## **Port of Lowestoft Berth Utilisation**

Rebuttal to Suffolk County Council submission REP8-005

May 2019

Figure 2. North Quay Berths and location of the proposed LLTC Bridge

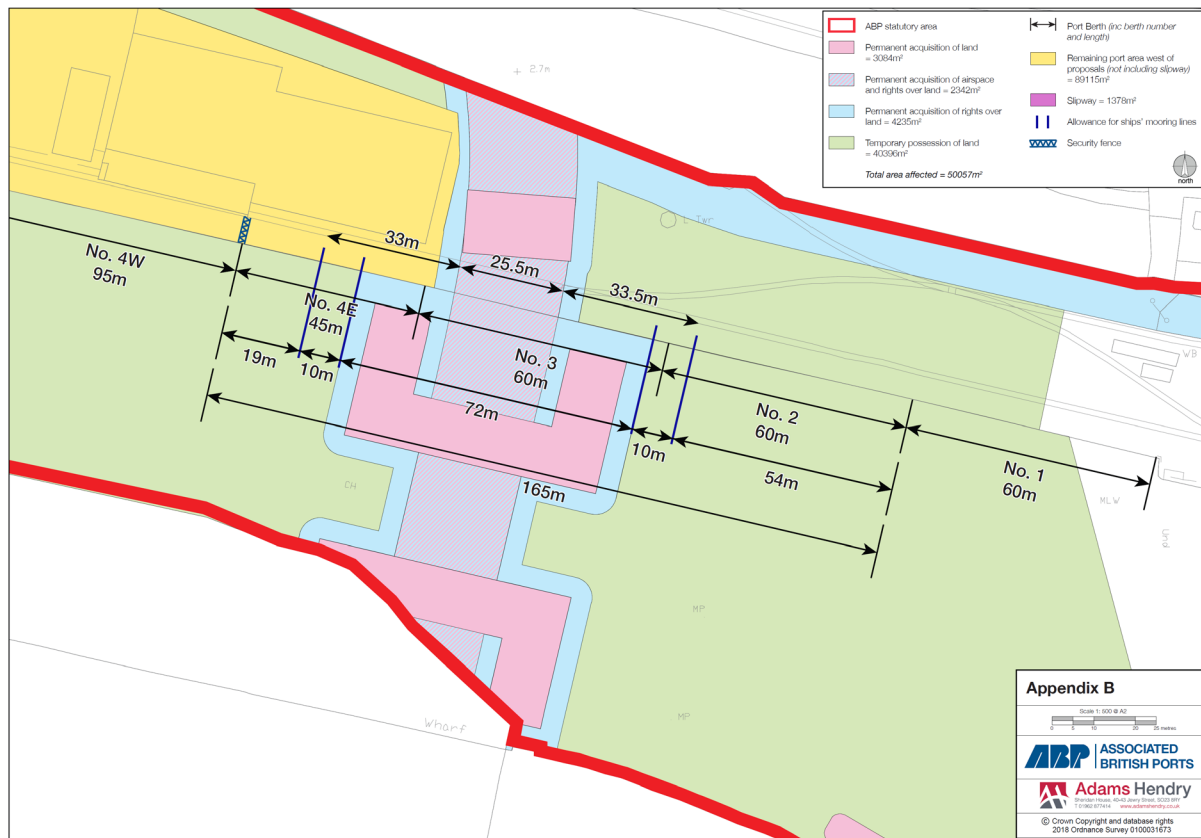
A large proportion of North Quay 4E is lost with the Scheme in place, since only 29 m of safely operational quay length remains (Figure 2, in the BUR). In Paragraph 3.2.11, SCC suggests this berth is still usable with over 30 m of quay length. It is not apparent how a quay length of "over 30 m" (i.e. 34.5 m taken from Paragraph 3.2.13, REP8-005) was determined.

Based on the information presented in Figure 2 of the BUR, a quay length of 29 m is not considered appropriate to safely berth any vessels, resulting in the berth becoming unusable. North Quay 4E was deemed lost in the BUR and was not included in the analysis for this reason. The restrictions on crane operations present at North Quay 4W frequently makes North Quay 4E a preferred alternative berth, which is an option that will be lost with the Scheme in place.
